FIRSTLY - Written copy of oral representation delivered by Stuart Shearer at the Open Floor Hearing at Dunston Hall, submitted at the request of the panel leader. The covering note identifies two factual corrections made since delivery and lists subsequent written submissions. The speech text is unchanged from what was delivered.

East Pye Solar — EN0110014 | Open Floor Hearing

East Pye Solar — Planning Inspectorate Reference EN0110014

Subject: Response to EXAM/9.1 — Request to Include Hawes Green Heritage Cluster and Market Lane in the Accompanied Site Inspection Itinerary for Site 8

Figure 28. Visibility Analysis Site 8

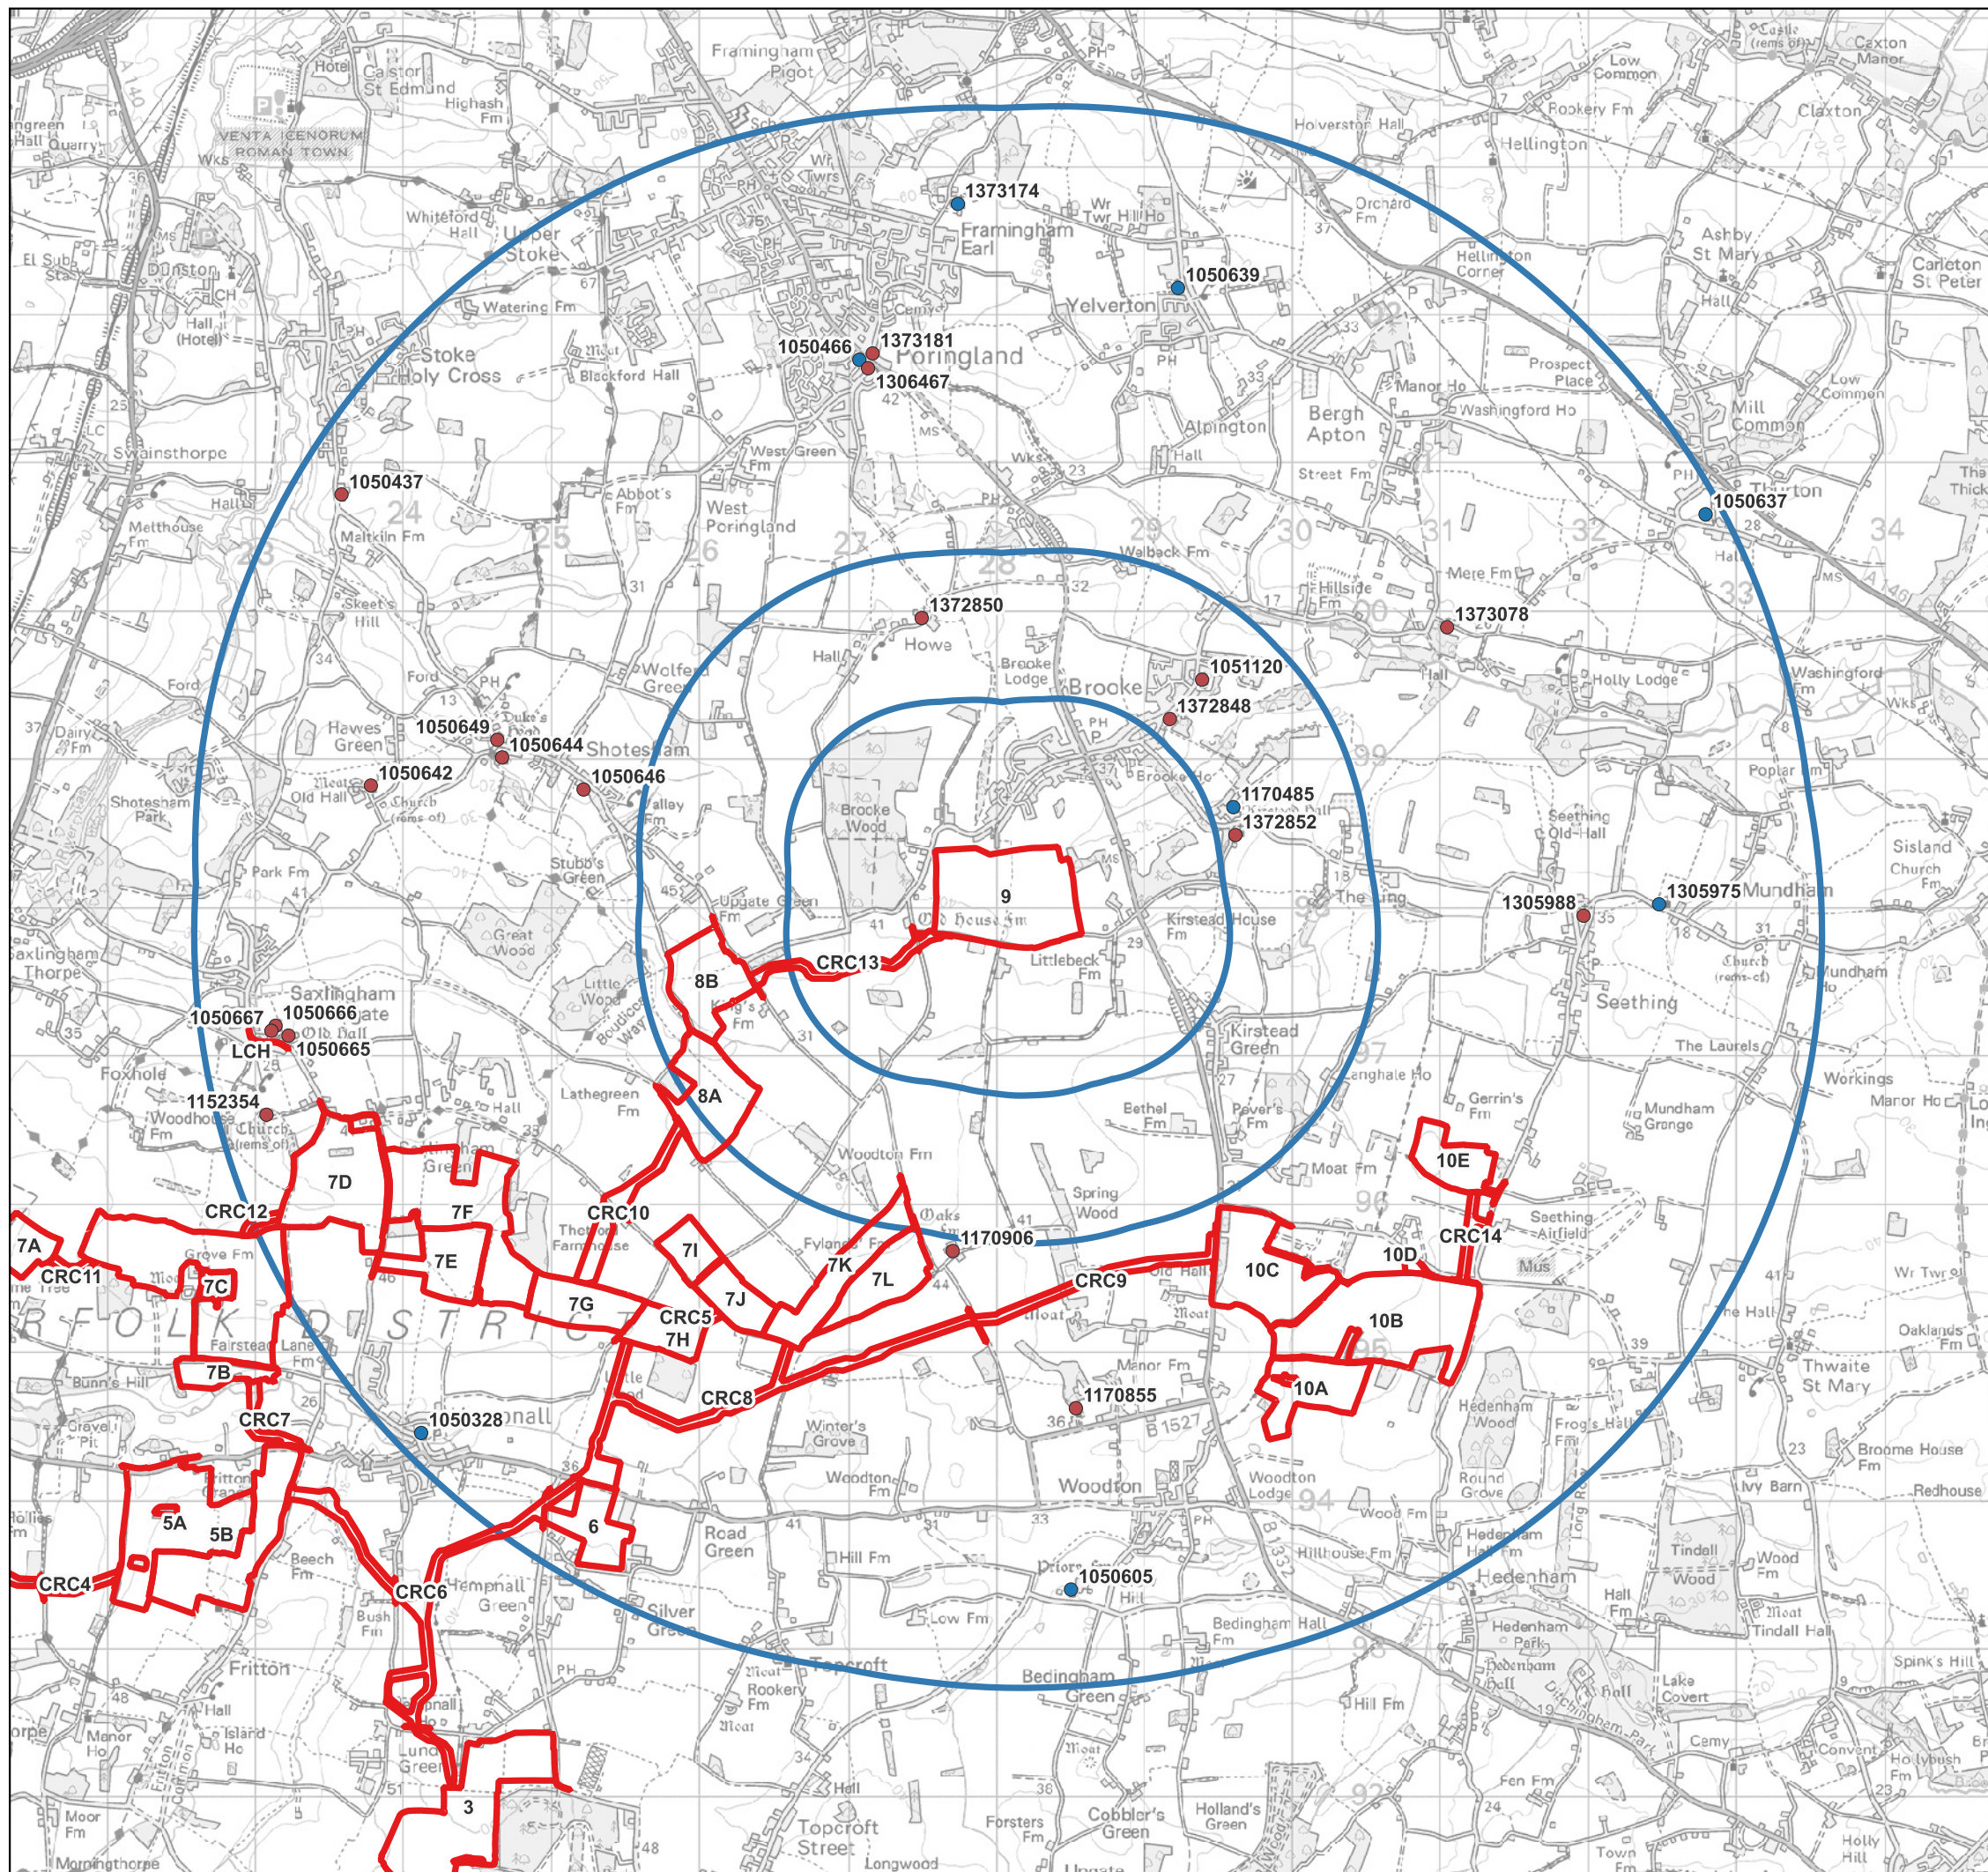
Second — the developer claims visual impact on Hawes Green is insignificant, yet elsewhere admits that glimpses and glimmers of the arrays will be visible from the footpaths of a Grade II* listed church. That is a direct contradiction. An admission of a glimpse is an admission of an unmitigated line of sight. Table 7.4 lists twenty-one assessed viewpoints for Sites 7 and 8. Hawes Green does not appear in a single one.

Second — the developer claims visual impact on Hawes Green is insignificant, yet elsewhere admits that glimpses and glimmers of the arrays will be visible from the footpaths of a Grade II* listed church. That is a direct contradiction. An admission of a glimpse is an admission of an unmitigated line of sight. Table 7.4 lists twenty-one assessed viewpoints for Sites 7 and 8. Hawes Green does not appear in a single one.

- The proposed panels along the western boundary of Sub-Site 8A would be most directly visible from Hawes Green
- The inter-visibility between the proposed panel location and St Mary's Church (Grade II*) can be most clearly demonstrated
- The topographical relationship between the valley floor at approximately 30 metres AOD and the Hawes Green ridge at approximately 38 metres AOD is most clearly experienced
- The inadequacy of the proposed 3 metre hedge screening — which reaches only 33 metres AOD — in screening panels visible from a ridge at 38 metres AOD is most clearly demonstrated

Two — a verified topographical cross-section is produced from St Mary's Church path to Site 8 to prove the screening mathematics.

Two — a verified topographical cross-section is produced from St Mary's Church path to Site 8 to prove the screening mathematics.
